Ref: 6/2023/1726/FULL
Date: 12/09/2023

HISTORIC BUILDINGS AND CONSERVATION ADVICE

RE: 26-52 Rooks Hill Welwyn Garden City AL8 6ET

The application is for replacement of existing timber double glazed windows with UPVC double glazing.

# INTERNALLY GLAZED CHAMFERED CASEMENT WINDOWS

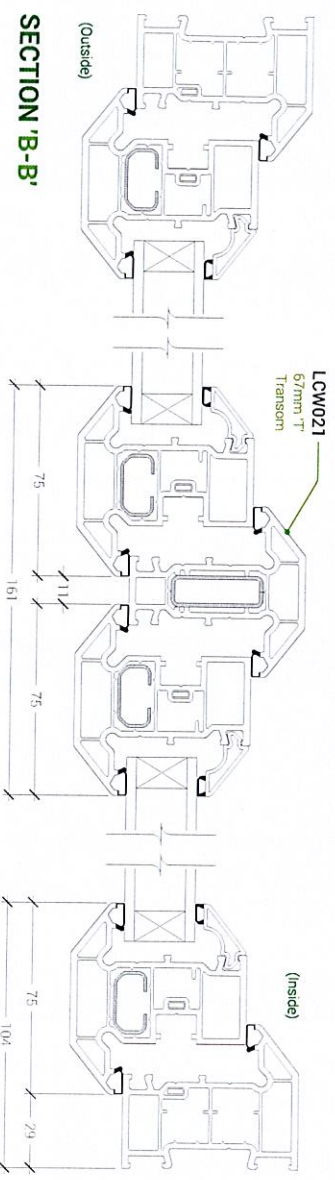
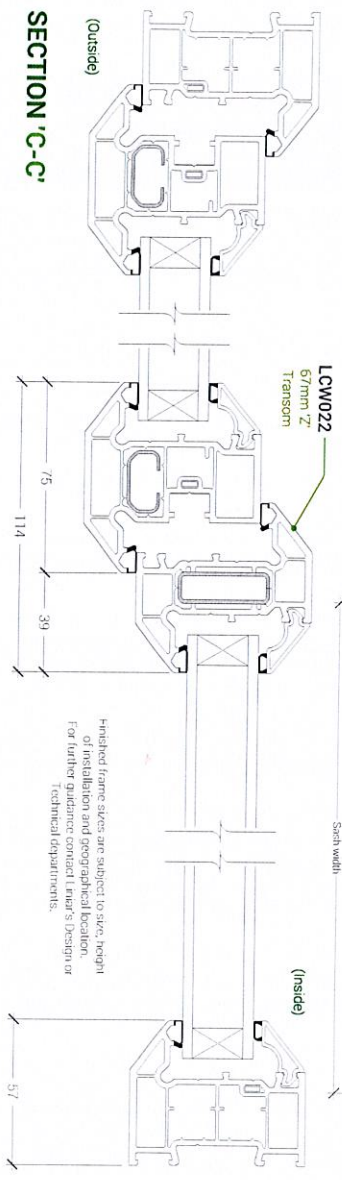
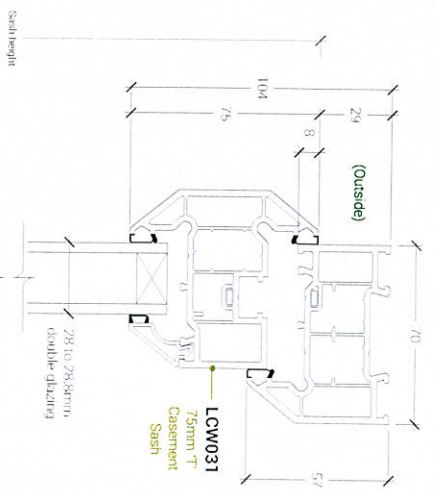
There is no objection in principle to the replacement of the existing windows if they are beyond viable repair, particularly as the proposal site is a late 20th century construction and no historic fabric would be lost. However, there is a strong objection to their replacement with uPVC as this is a modern material which does not uphold the quality of the historic environment and cannot replicate the detail of timber windows. It is modern in finish and overall appearance and detracts from the character and appearance of the Conservation Area. While the proposed design would match the existing, it is unlikely that double glazed uPVC units will exactly match the detailing of the existing timber windows due to the need for thicker frames and surface applied glazing bars as illustrated in the supporting documents.

The different appearance and character of PVC-u windows compared to historic windows is highly likely to make them unsuitable for older buildings, particularly those that are listed or in conservation areas... these windows are assembled from factory-made components designed for rigidity, thermal performance and ease of production. Their design, detailing and operation make them look different to traditional windows. Manufacturers have been unable to replicate the sections/glazing bars used in most timber and steel windows due to the limited strength of the material and the additional weight of the secondary glazing units. False 'glazing bars' which are thin strips of plastic inserted within the glass sandwich of a double glazed unit change the character of the window.

The proposed uPVC windows are therefore considered to undermine the character and appearance of the Conservation Area. With regards to the National Planning Policy Framework (2021), the level of harm to is considered to be 'less than substantial'. As such the local planning authority should weigh this harm against any public benefits of the proposal including, where appropriate, securing its optimum viable use as per Paragraph 202. Furthermore, the proposal fails to make a positive contribution to local character and distinctiveness, as set out in Paragraph 197c of the NPPF.
